From: Speer Dade Planning Consultants [REDACTED]
Sent: 03 July 2020 11:25
To: Planning <Planning@arun.gov.uk>
Cc: Andrew Wood <Andrew.Wood@arun.gov.uk>
Subject: FG/6/20/PL representations

I refer to the representations made on 11 March 2020 on behalf of Mr Geoffrey Fox of Reynard's Nursery, Hangleton Lane, Ferring BN12 6PP, in respect of this application.

I have seen the desktop noise assessment by Acoustic Associates Sussex Limited and, on behalf of our client, comment as follows.

Figure 13. Predicted External Noise Levels at both Residential and Equestrian Centre Uses

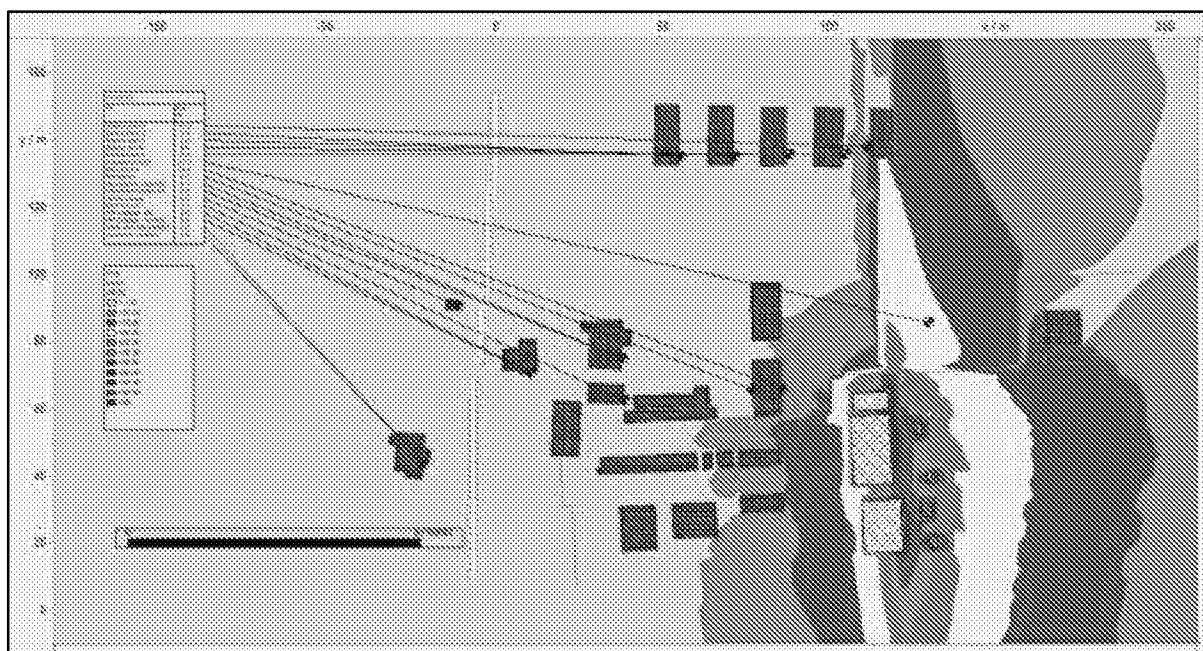
The report identifies four residential receptors, outside the application site, which were assessed for noise impact. These, and their approximate distances to the proposed kennels (the latter taken from the previous representations), were:

Carol Anne House	137m
White Lodge	129m
Highdown Hill Cottage	98m
Hangleton Lodge	75m

The noise assessment did not consider the impact on the dwelling at Reynard's Nursery, which is about 134m from the proposed kennels, that is, a similar distance to Carol Anne House and White Lodge. There is also a dwelling about 106m from the proposed kennels (labelled E on the aerial photo submitted with the previous representations) which was not assessed either.

As set out in the previous representations (page 2), our client keeps a number of horses on the land immediately adjoining the application site to the south of the proposed kennels. The impact on this equestrian use was not assessed.
